Retreat at TimberRidge
PUD Development Plan
EL PASO COUNTY, CO

DATE:	BY:	DESCRIPTION:
06-21-17	KMM	Per County Review Comments

PUD DEVELOPMENT PLAN

PHASE MAP

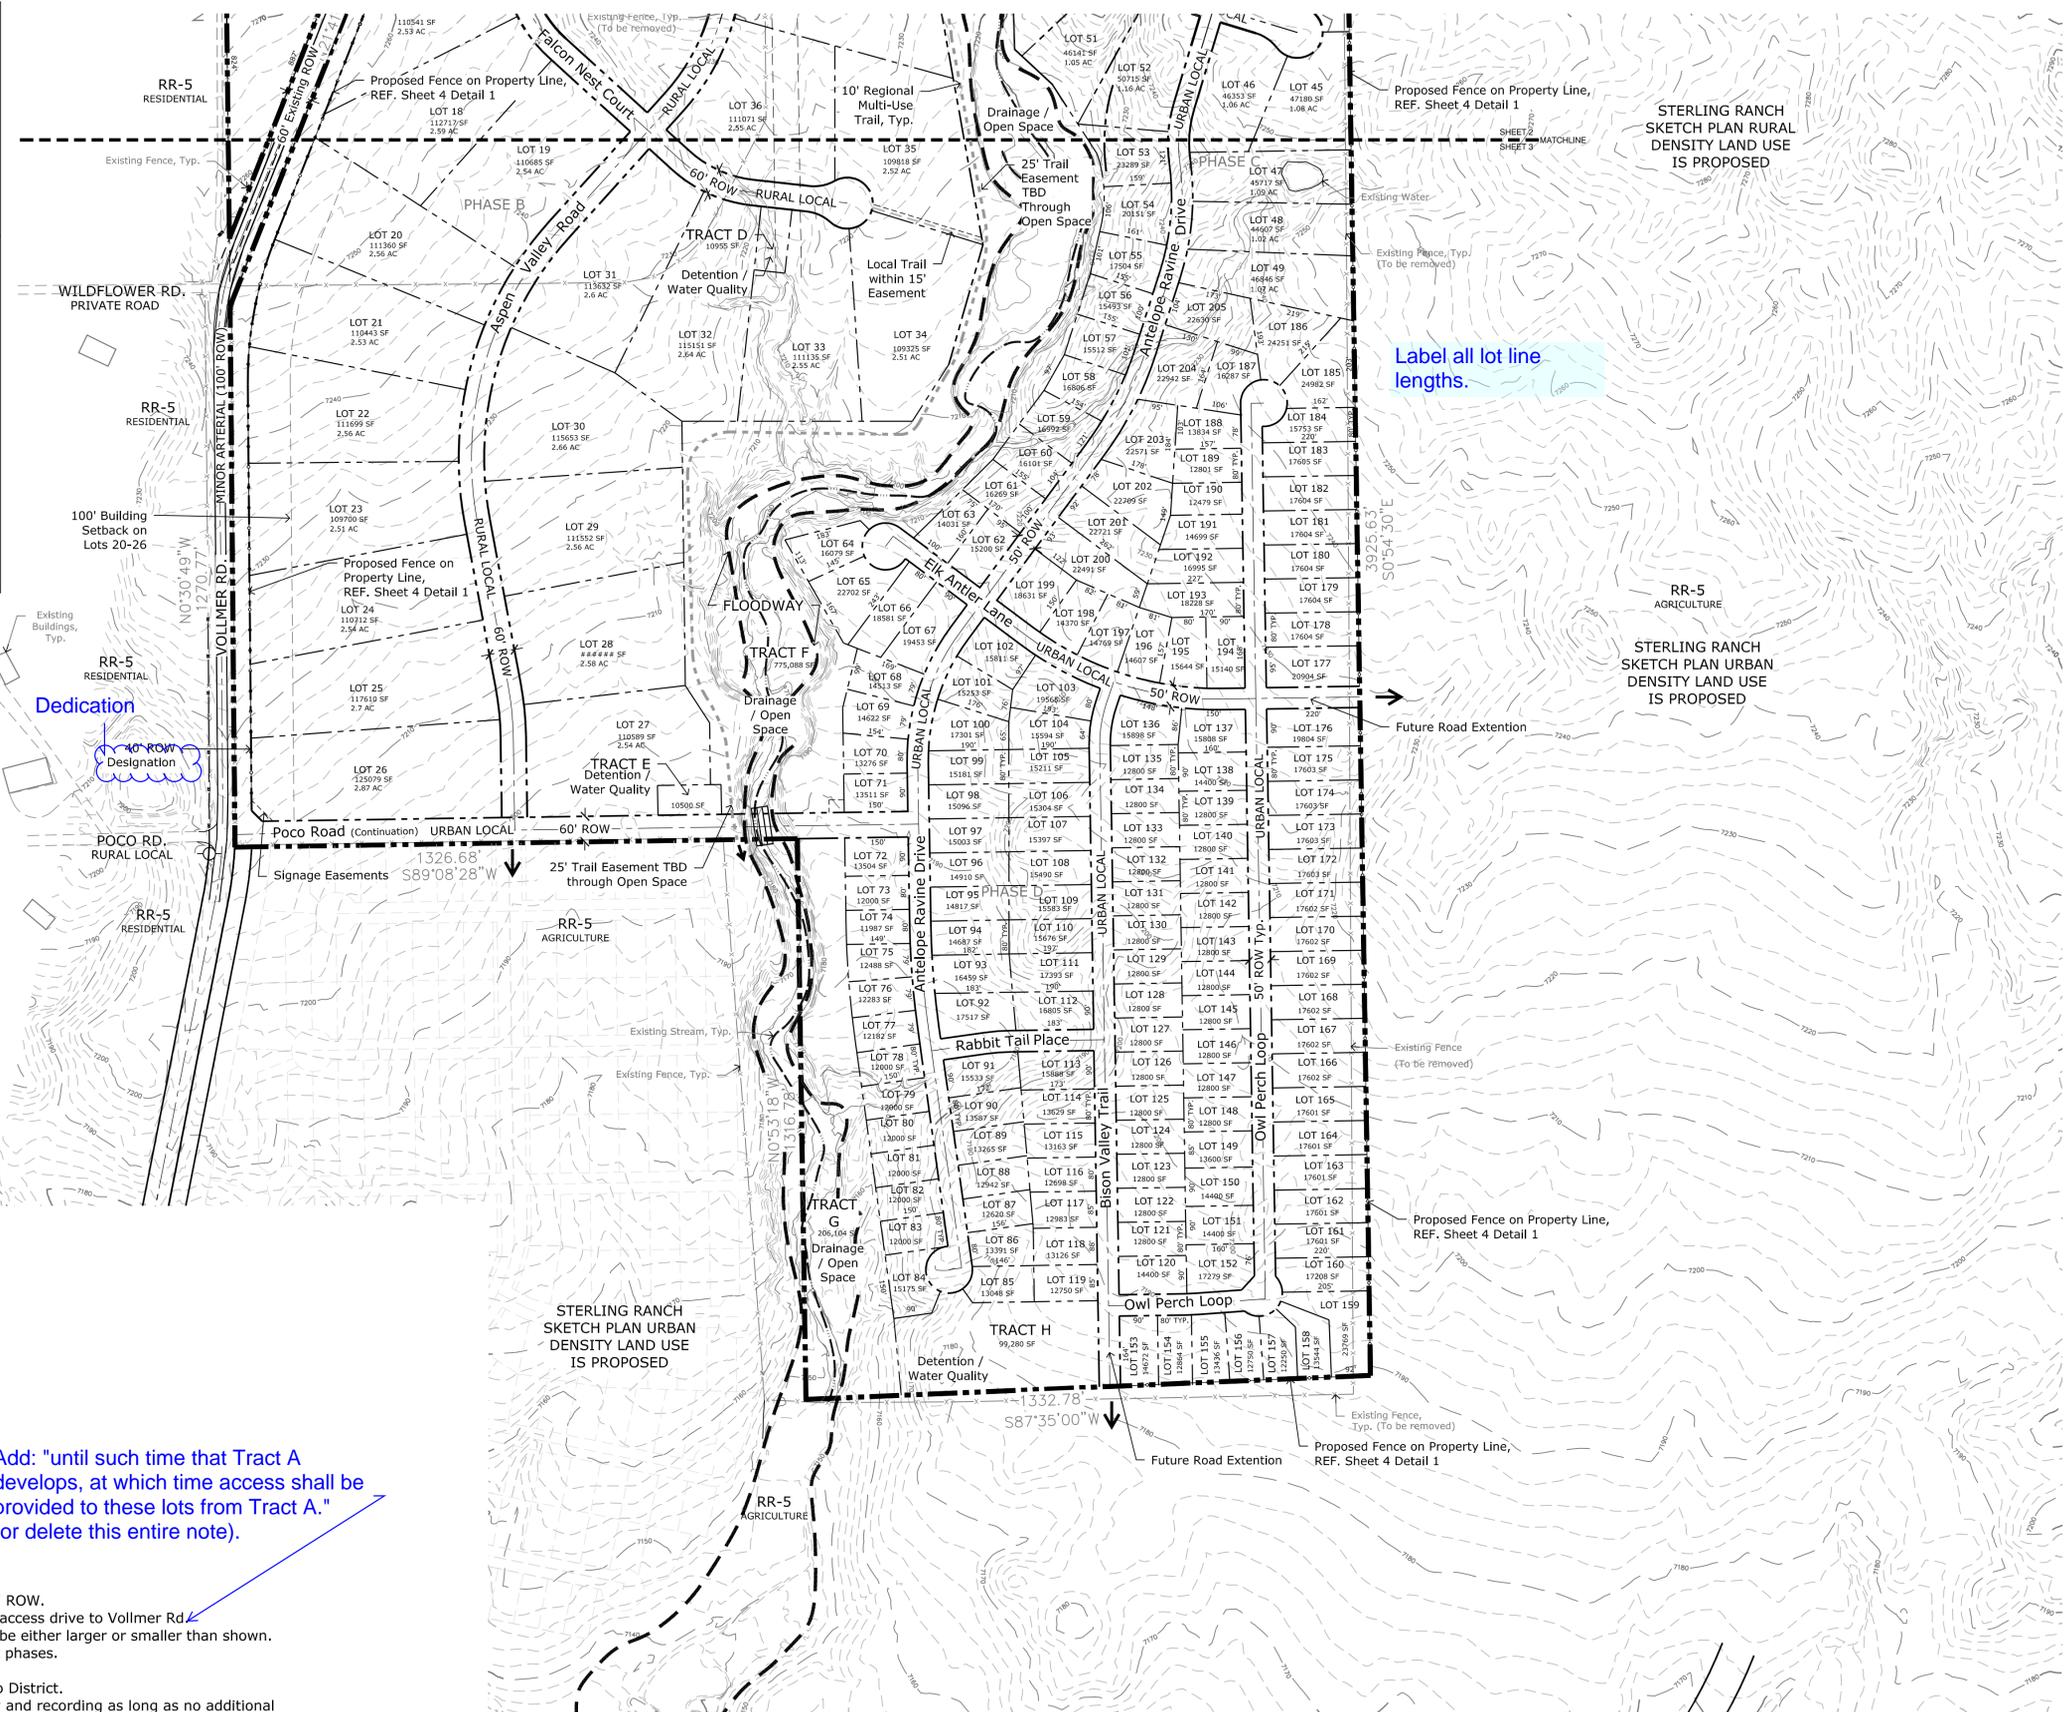
This access requires a deviation (not allowed on arterial).

Provide existing contours if available

Needs to be a cul-de-sac. Address snow storage.

This turnaround is not necessary. Pavement can end just past intersection and pedestrian ramps.

Address snow storage

Needs to be a cul-de-sac. Address snow storage.
